90-102 Regent Street, Redfern (SSD-10382)

Thank you for your correspondence via the Major Projects portal on 10 November 2020, requesting Transport for NSW (TfNSW) to review and comment on the above.

**Figure 3.3: Vehicle Loading Area (Lower Ground Floor)**

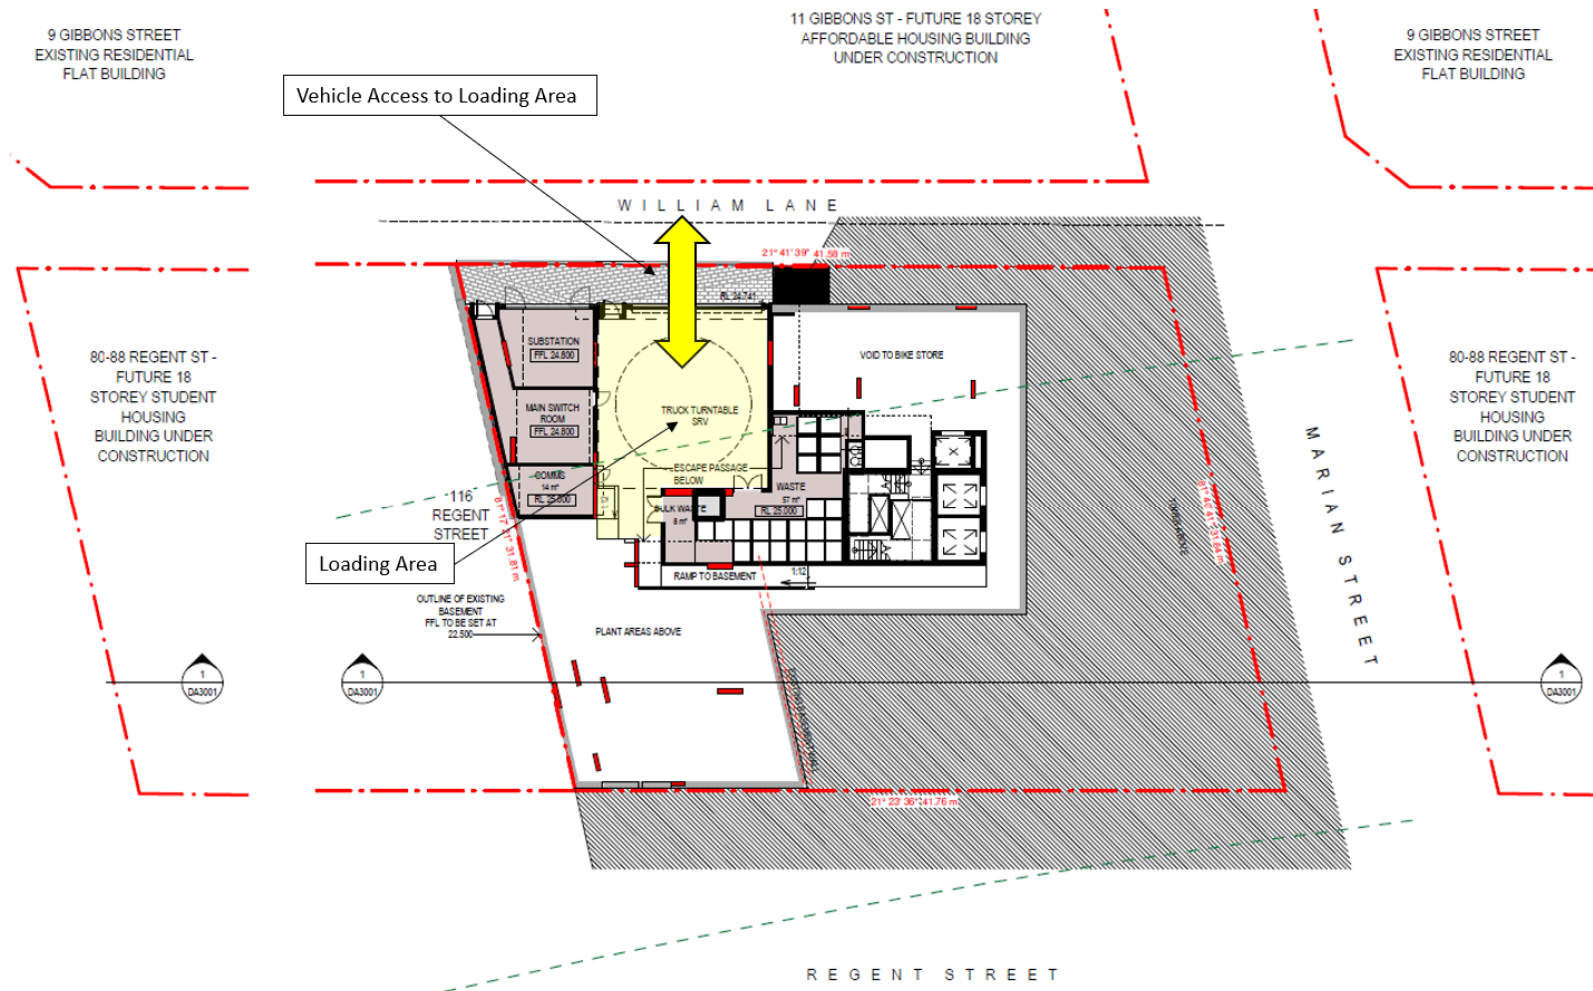
Section 3.1 of the Traffic Impact Assessment Report prepared to support the development application states that the loading area has been designed to accommodate a Small Rigid Vehicle (SRV 6.4m long) as defined by AS2890.2.

It is advised that the single loading bay is unlikely to be sufficient to service the proposed development, which is to accommodate 381 student apartments. At the beginning and end of universities semesters, it is likely that there would be movement of student residents of this and other nearby student accommodation developments. As a result, there would be demand for servicing activities (such as removalist and the like) which is likely to exceed the capacity of the proposed facilities during this period.

The response to submissions should address the above matter, including the verification of demand for loading and servicing requirements. This may require additional facilities to be provided as part of the development.

It is requested that the applicant be conditioned to prepare a Loading and Servicing Management Plan in consultation with TfNSW, prior to the issue of any Construction Certificate.
